Rezoning Transportation Analysis

Petition Number: 2024-003

From: Jake Carpenter, PE

Date	Description
2-21-24	First Review (IW)

SHEET NUMBER  
**RZ-1**

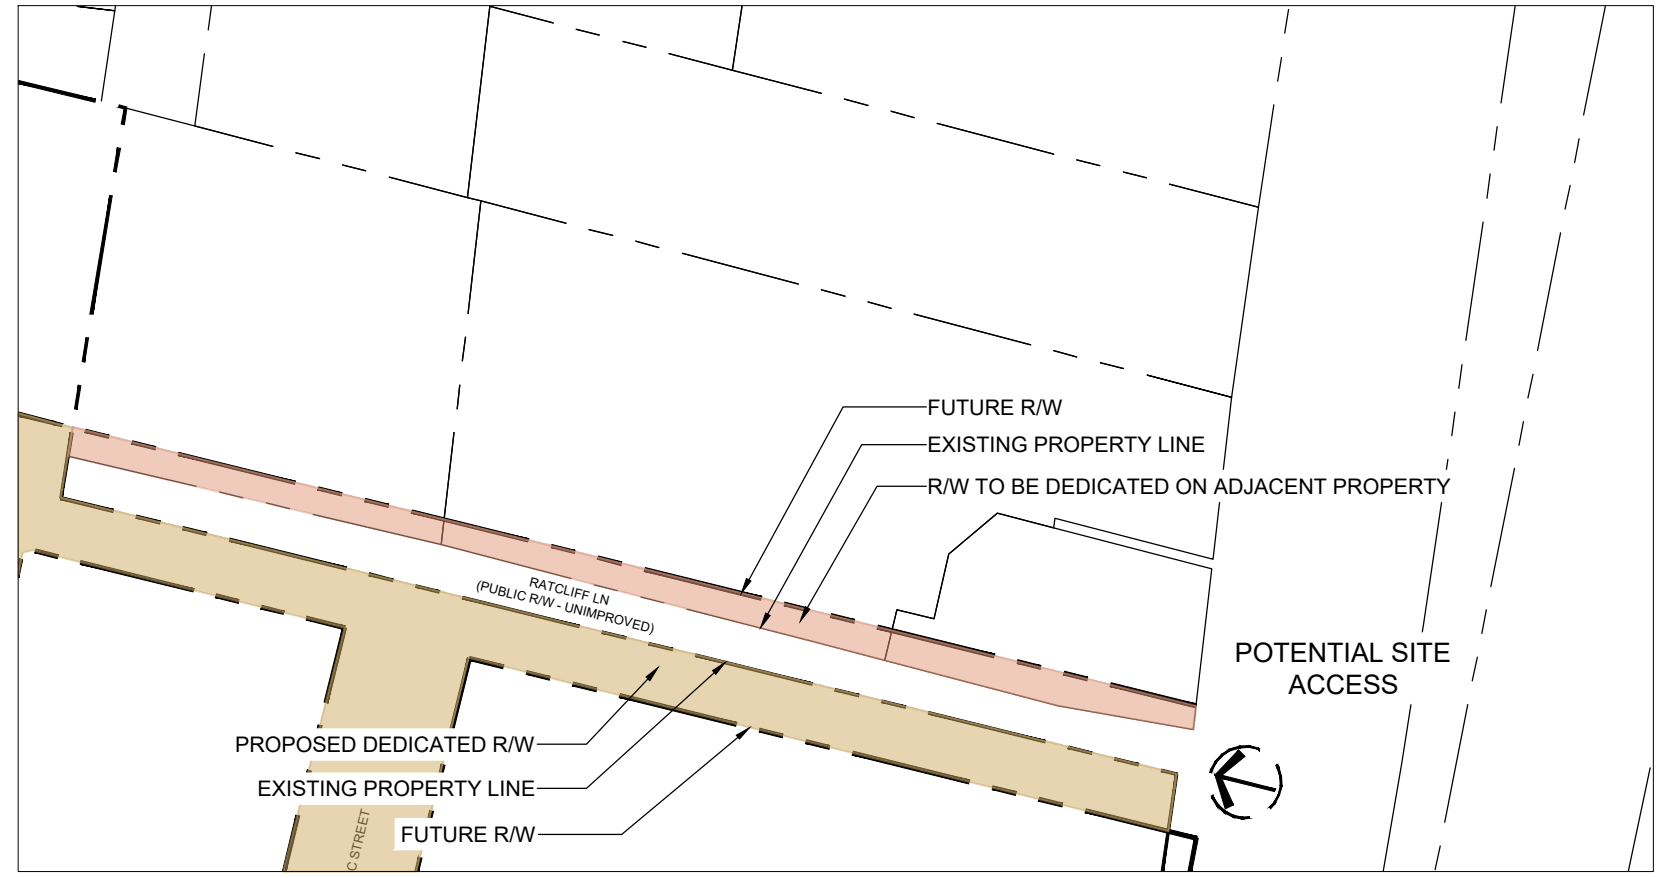
- a. **Old Statesville Road:** Location of future back of curb and gutter to be moved 35 feet from centerline.

- b. **Ratcliff Lane:** Location of future back of curb and gutter needs to be moved to 17.5 feet from the road centerline per Article 33 in the UDO.

Label and dimension the curb and gutter from the centerline for each road on the site plan.

3. Revise site plan and conditional note(s) to commit to dedicate a minimum 49 feet of right-of-way from the Old Statesville road centerline. The site plan shall label and dimension the right-of-way from the road centerline.

4. Revise site plan and conditional note(s) to commit to dedicate right-of-way for Residential Wide Typ. Section U-03A2 for Ratcliff Lane.
5. Revise site plan and conditional note(s) to commit to maintaining existing bike lane alignment and/or construct bicycle facilities where curb is not already in it's future location by locating the curb and gutter 35' from the center line.

7. Revise site plan and conditional note(s) to commit to constructing Ratcliff Lane to a Residential Wide Cross-Section to meet CLDSM Standard U-03A2 per Article 33 and table 33-2 in the UDO.

8. Revise site plan and conditional note(s) to commit to realigning all connections to public streets to be perpendicular with the road for better safety, instead of the angle for which some of the accesses are connecting. (See snip below)

9. Revise site plan and conditional note(s) to commit to labeling the street type. (ex. Local Residential Wide, Local residential medium, etc.) for each public street on the site plan.
10. Revise site plan and conditional note(s) to commit to label if southern access will be an access point or not. If not, label as street stub and provide a turn around. If so, show and label as an access.

Site plan only labels Ratcliff Lane as "potential site access".

11. Revise site plan and conditional note(s) to commit to showing existing median on Old Statesville Road, as the Ratcliff Lane access is currently right in/right out.
12. NCDOT REQUIREMENT: Revise site plan and conditional note(s) to commit to a 100' stem along Ratcliff Lane from Old Statesville Road.
13. Add a conditional note specifying "the Petitioner shall dedicate and convey in fee simple all rights-of-way to the City before the site's first building certificate of occupancy is issued. CDOT requests rights-of-way set at 2' behind back of sidewalk where feasible."
14. Add a conditional note specifying "All transportation improvements will be approved and constructed before the site's first building certificate of occupancy is issued."
